Fire Marshal Division

RE: Harnett County Resource Center and Library
455 McKinney Parkway
Lillington, NC 27546

Re: Application Number – FMFW1907-0006

SHEET NUMBER: G113

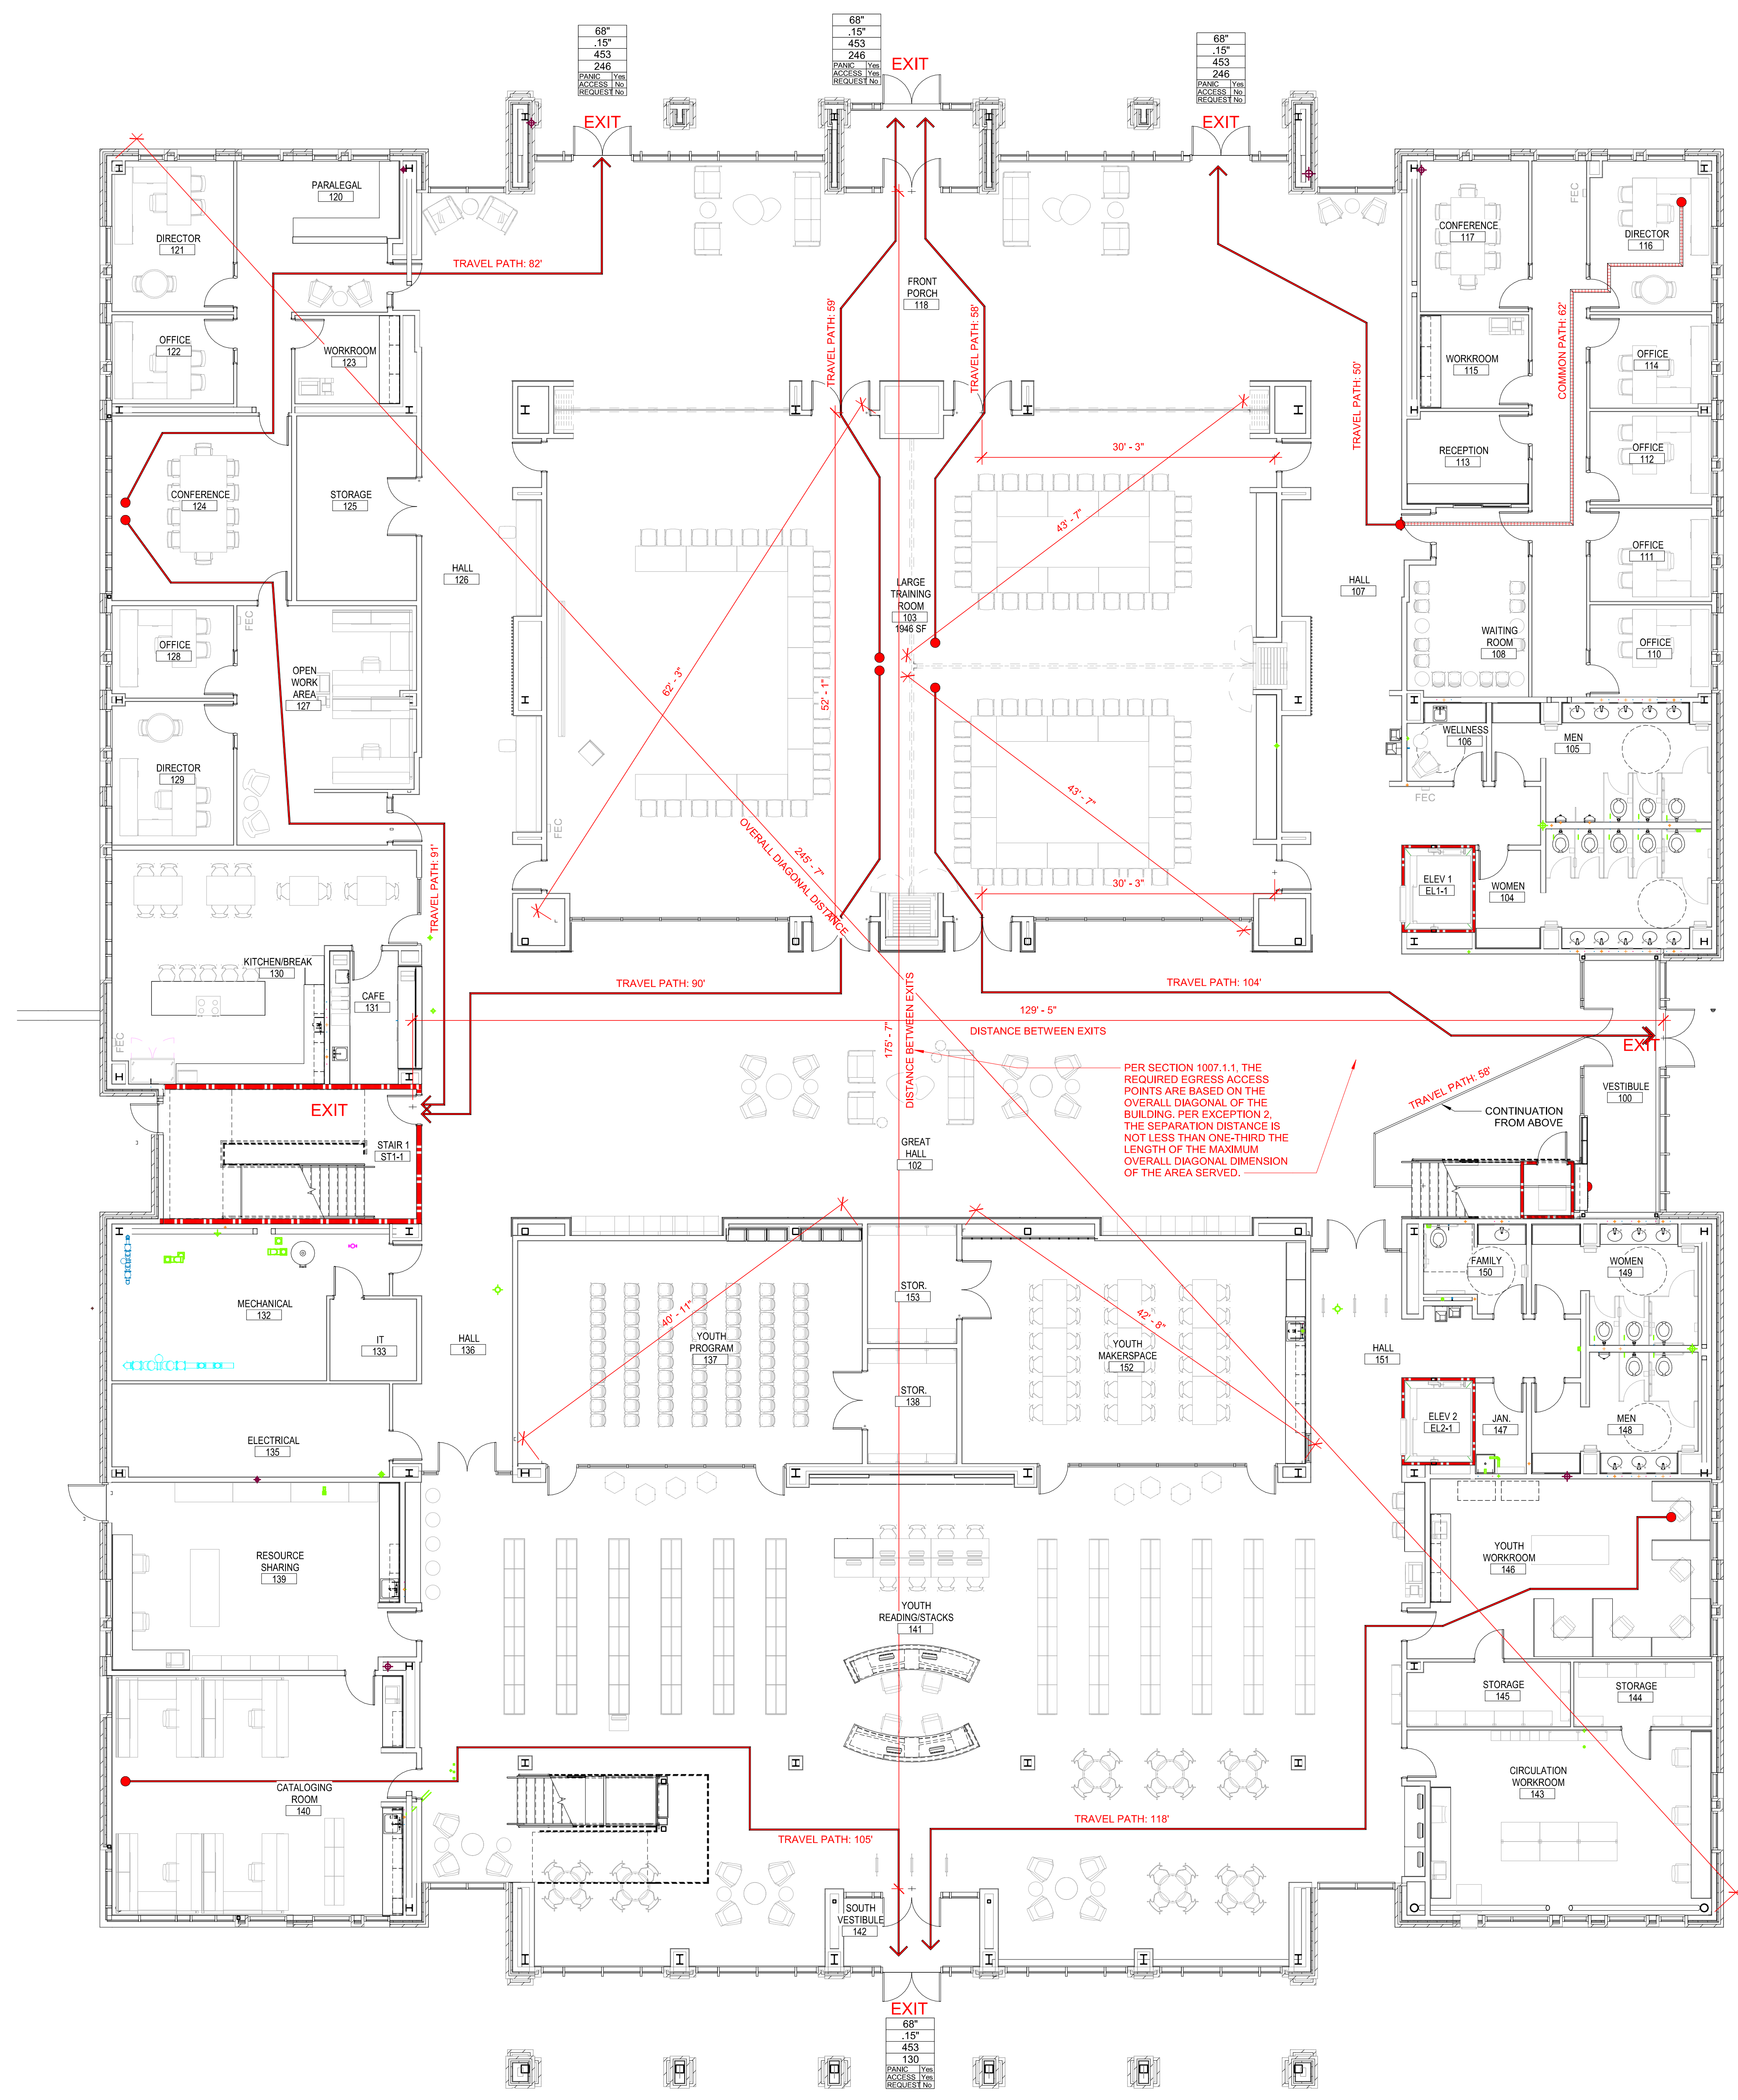
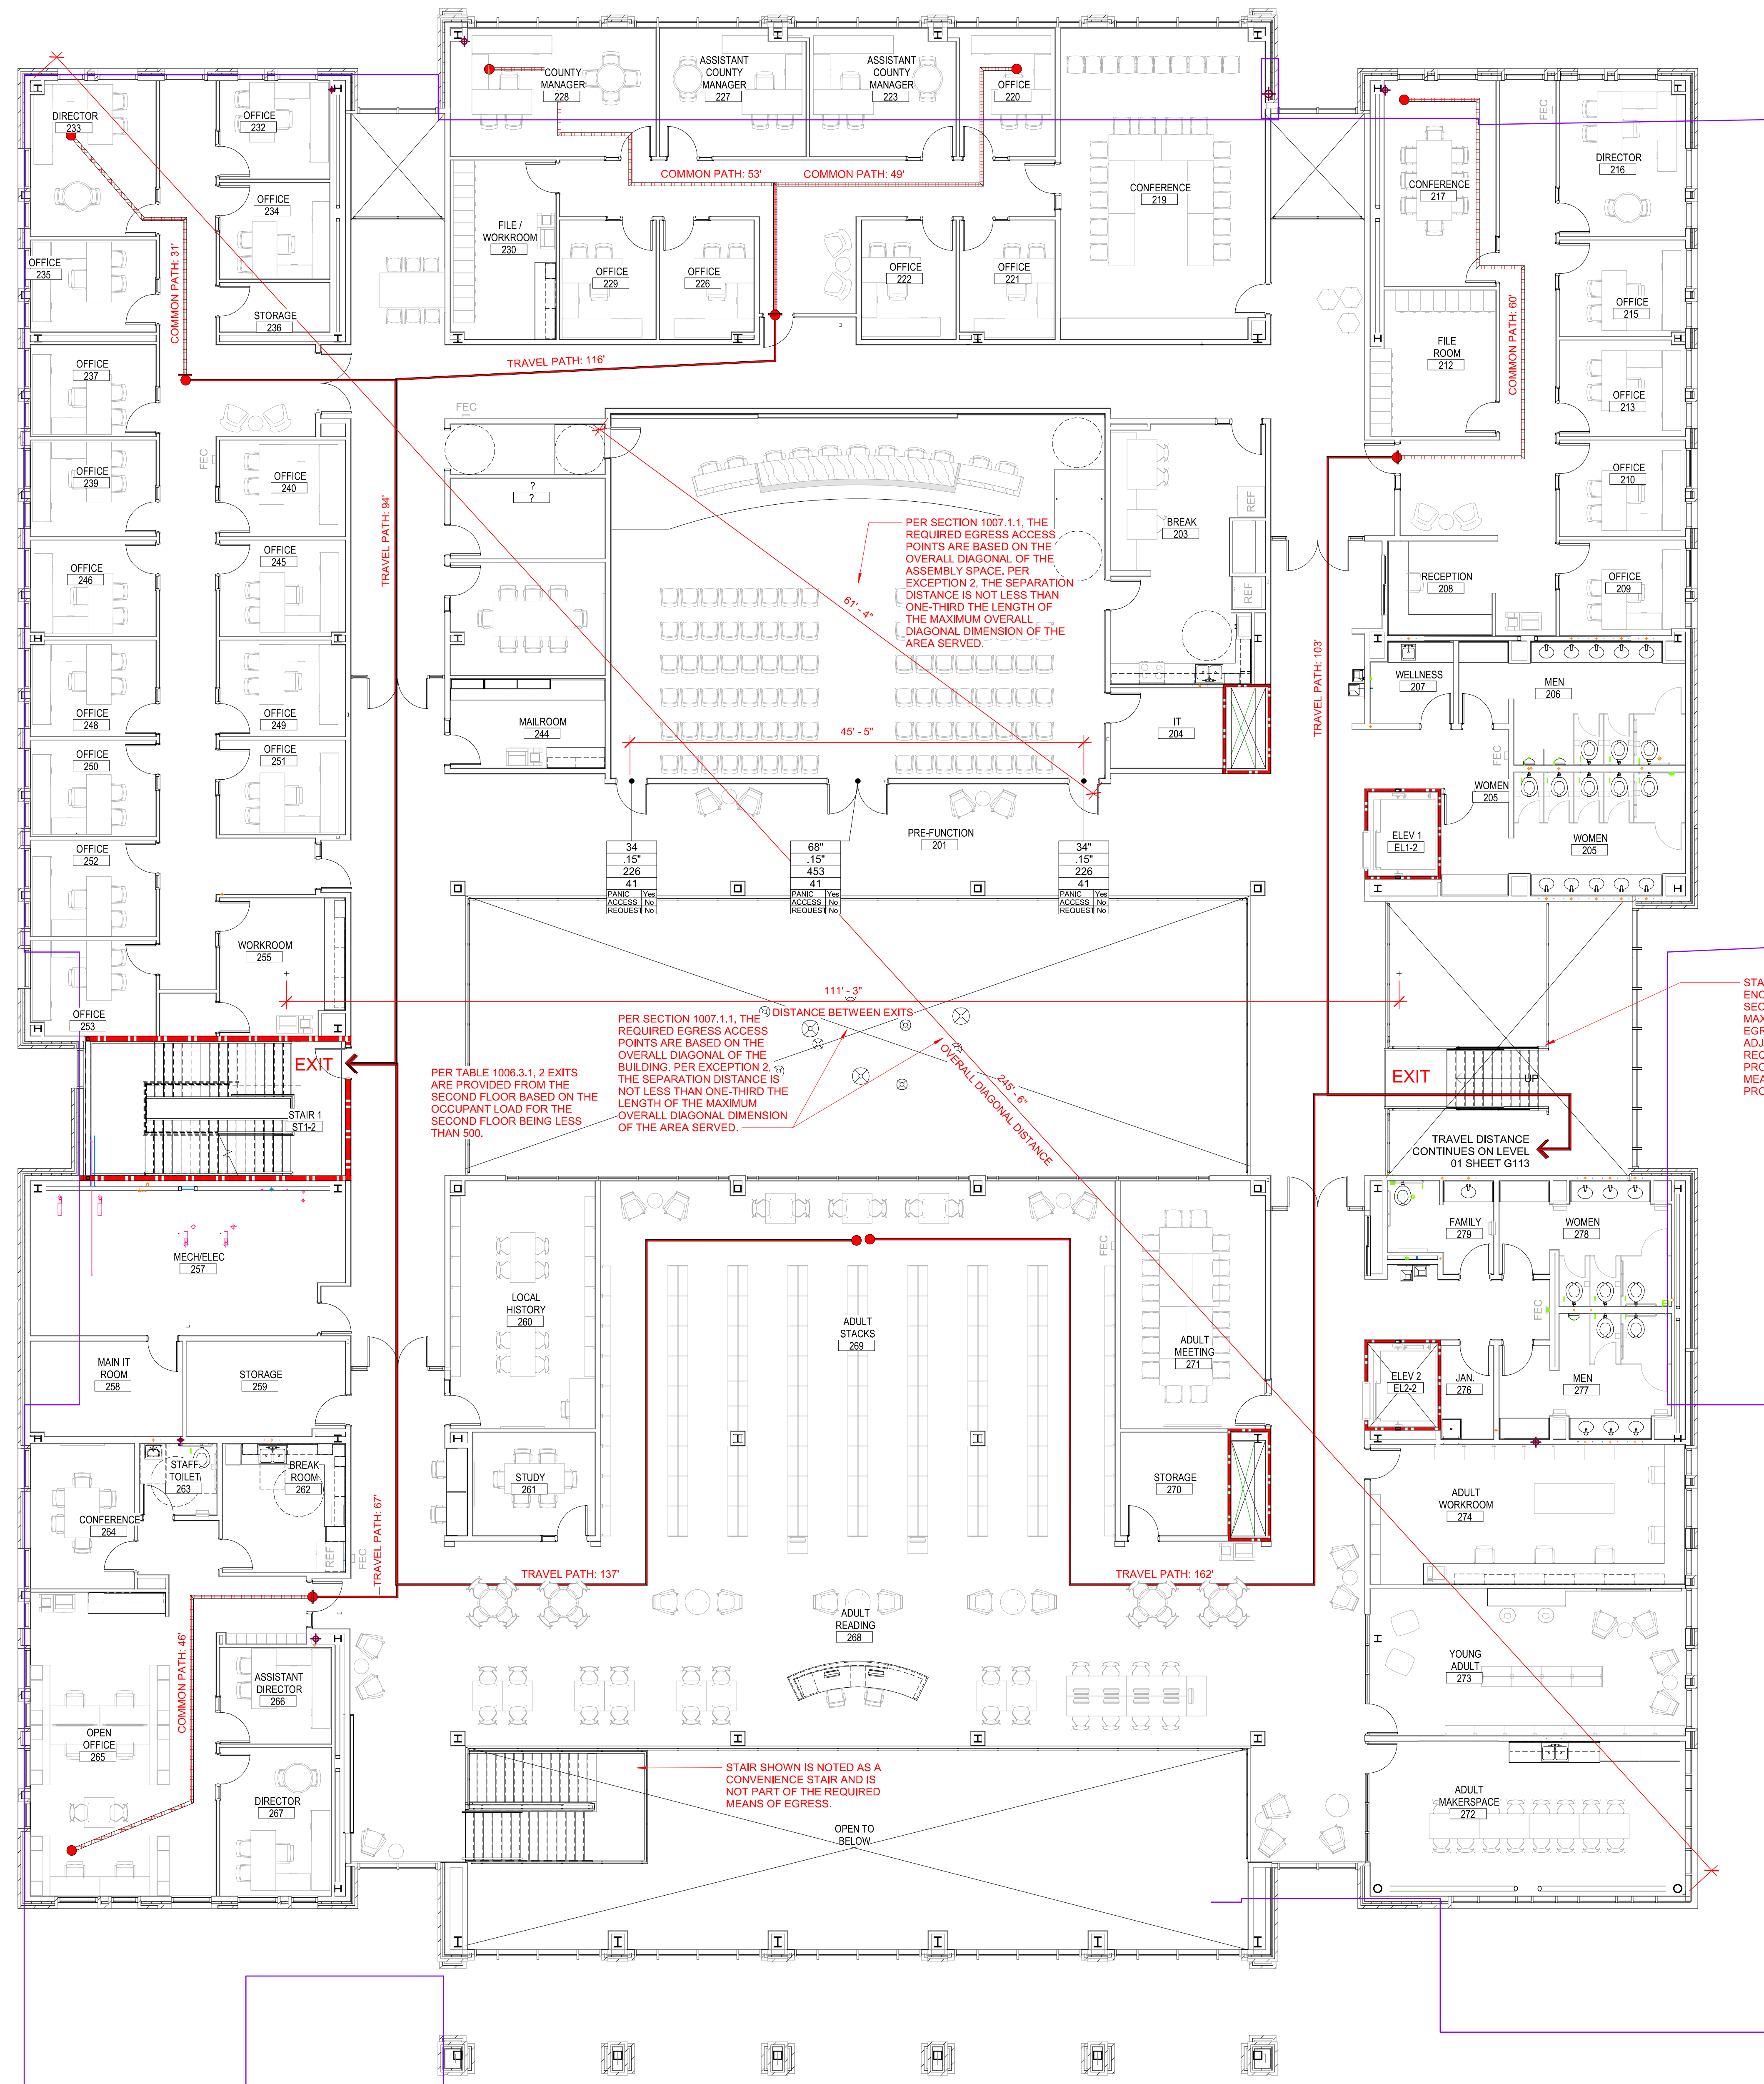
- A rough in inspection is required.
- A final acceptance test is required.
-
- **Notes**
 - Please clarify direction of exit signs; second middle of building, second floor at stairs, first floor at stairs (as shown on markup)
 - Please contact the Fire marshal's office to schedule fire final inspection when work is complete, 910-893-0742
